# ROLLING MEADOWS-BULL HILL CHANNEL & FLOODPLAIN

## 60% DESIGN GEC PLANS

## MODIFICATION GRADING AND EROSION CONTROL PLAN MARCH 2023

MATRIX PROJECT No. 21.1129.009

**EROSION CONTROL OVERVIEW SHEET 1**

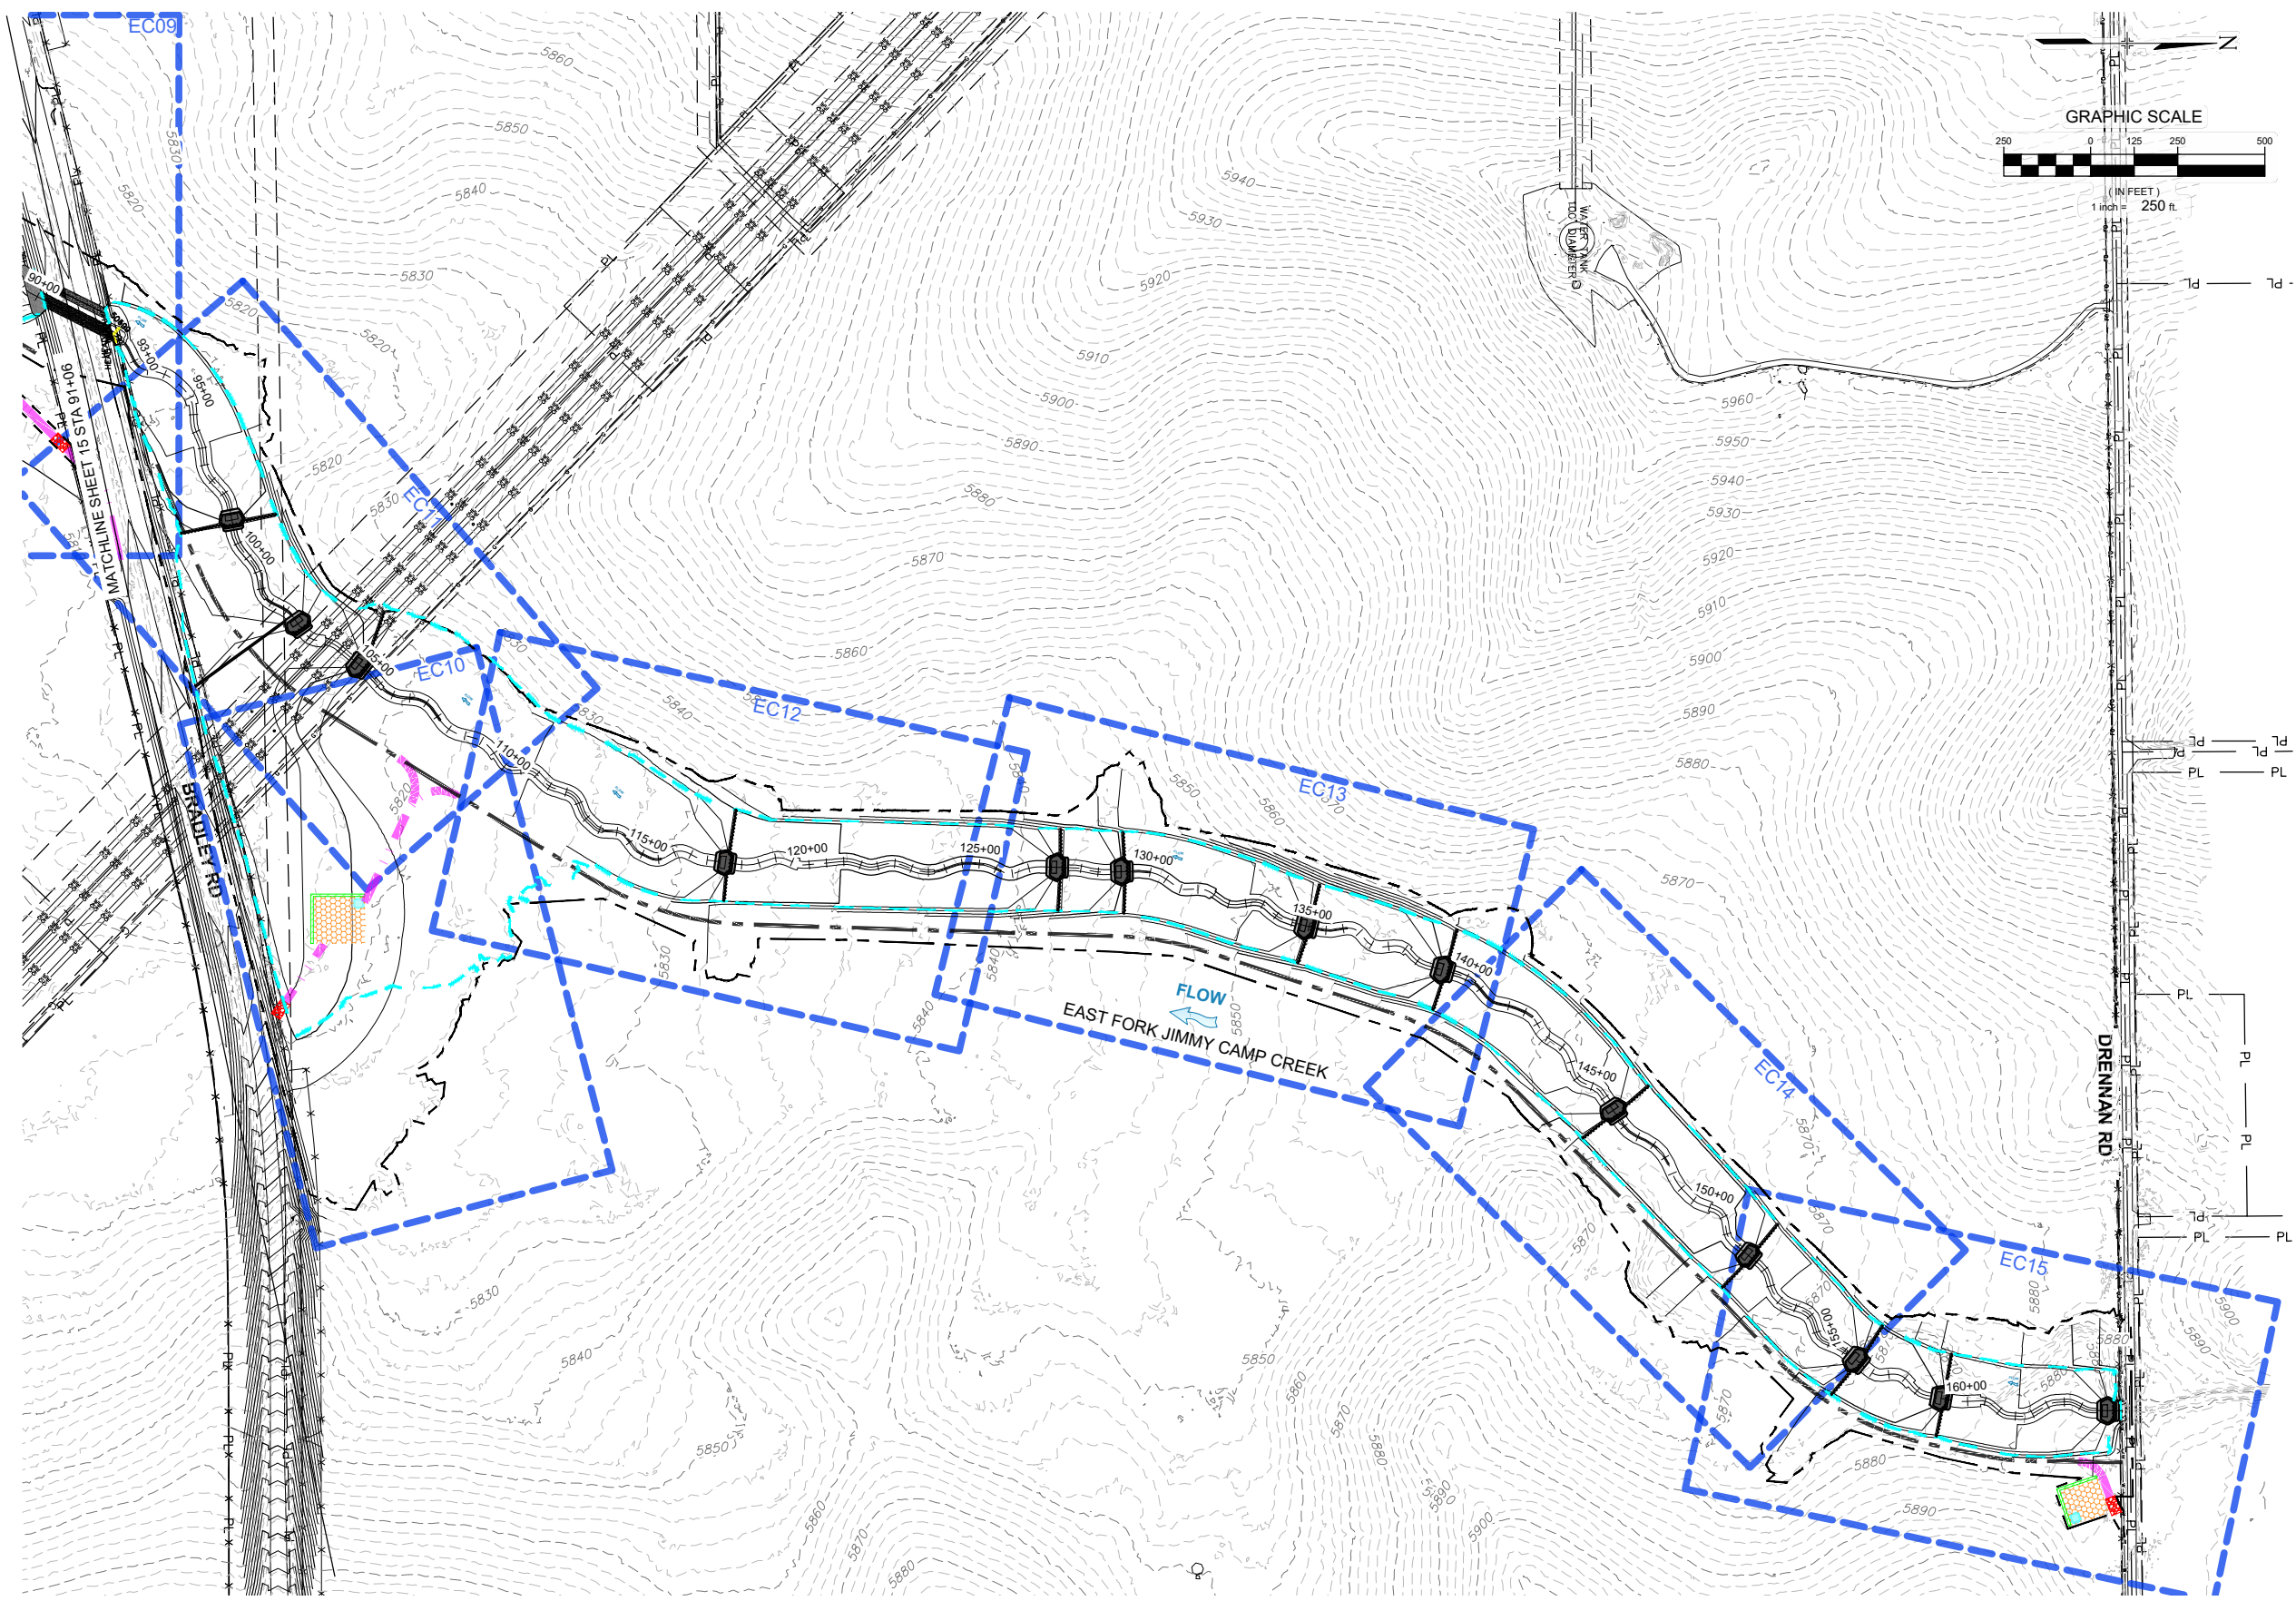
Unresolved.

On the 60% Design Plans (Design Plans\_v1), I had asked that the two Erosion Control Plan Sheets EC01 and EC02 be include in the GEC (or that the GEC be combined with the deign plans into one document). These two Sheets were removed from the Design Plan but they were not added to the GEC. Please revise accordingly.
